Our Ref: BR/282/19/PL

**Town & Country Planning Act 1990 (as amended)
Town and Country Planning (Development Management Procedure) (England) Order 2015
Application for Planning Permission**

Development Redevelopment into 49 No apartments consisting of 24 No 1 & 25 No 2 bed apartments & 2 No commercial units (A3 Restaurant & Cafe). This application affects the character & appearance of The Steyne, Bognor Regis Conservation Area & may affect the setting of a listed building.

Location The Beach Hotel, former Mud Club & 2-4 Waterloo Square Bognor Regis

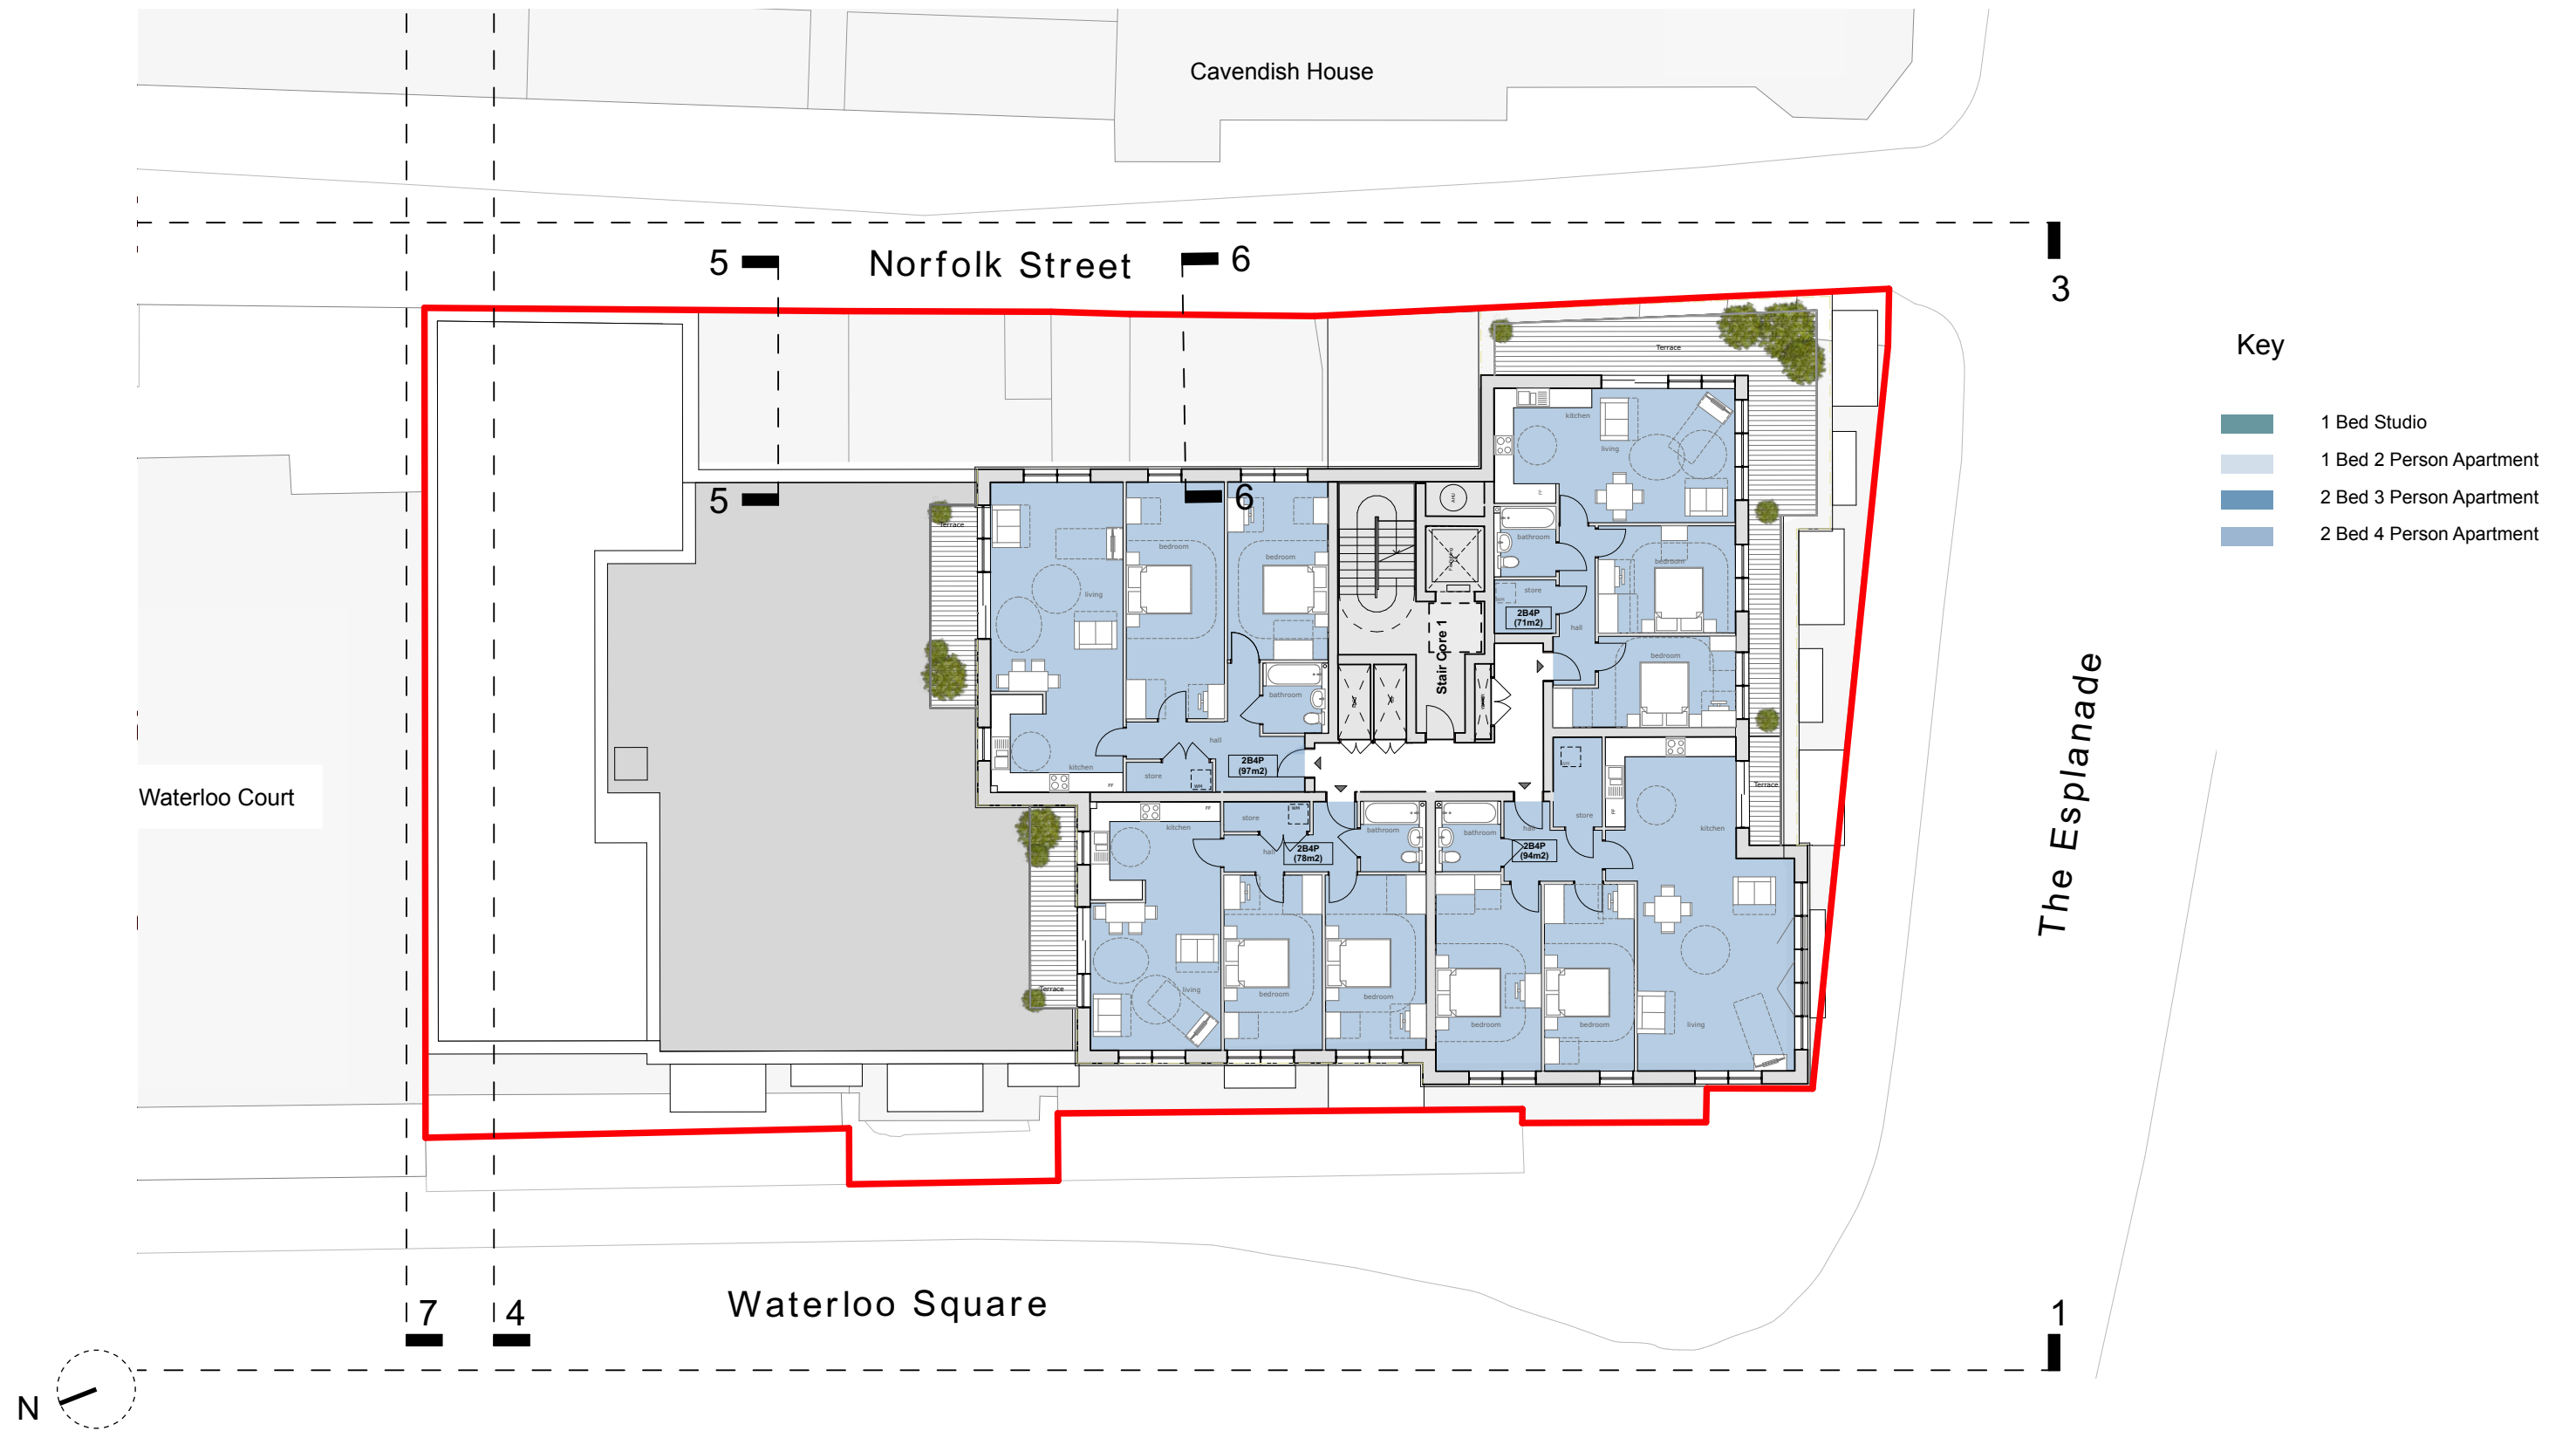
On the application form, a total of 24 parking spaces are indicated whilst only 22 proposed parking spaces are shown on the proposed basement plan. Please amend accordingly.
